SUBJECT: SFD1909-0036
SINGLE FAMILY DWELLING

Here are the results of all Inspections located at **111 LAVENDALE LN:**

**FOUNDATION PLAN**  
 SCALE: 1/4" = 1'-0"

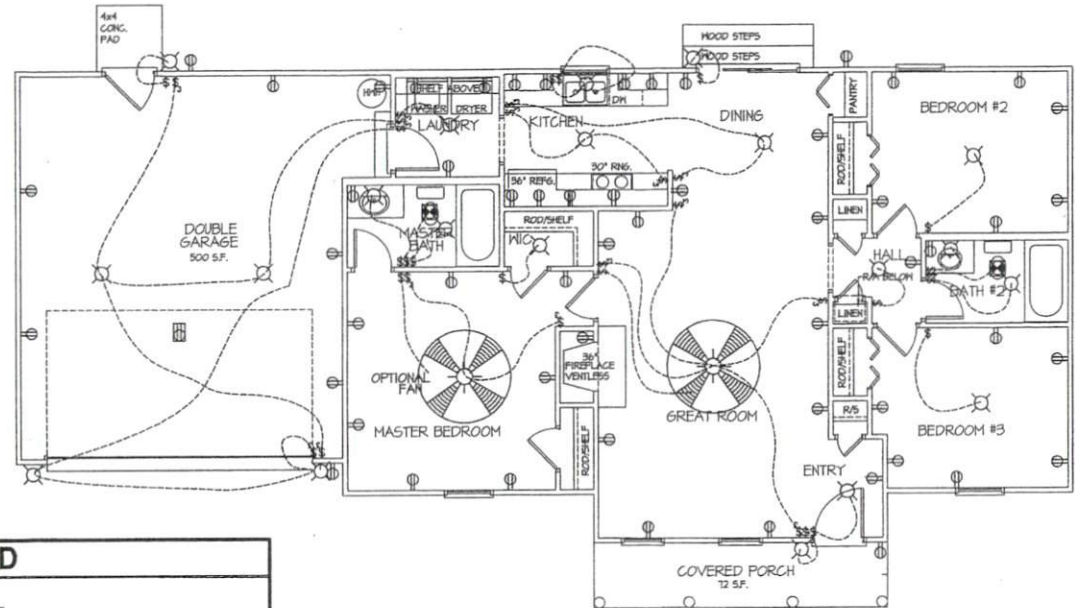
Provide engineering letter on soft soils and undercut and stone filled areas. Ensure foundation projection on 2 house to covered porch piers.

Inspection Type: FOOTING
Scheduled Date/Time: 5/14/2020
Completed Date/Time: 5/14/2020
Inspector: Deen Taylor
Result: APPROVED
Remarks: letter in attach.
Notes:
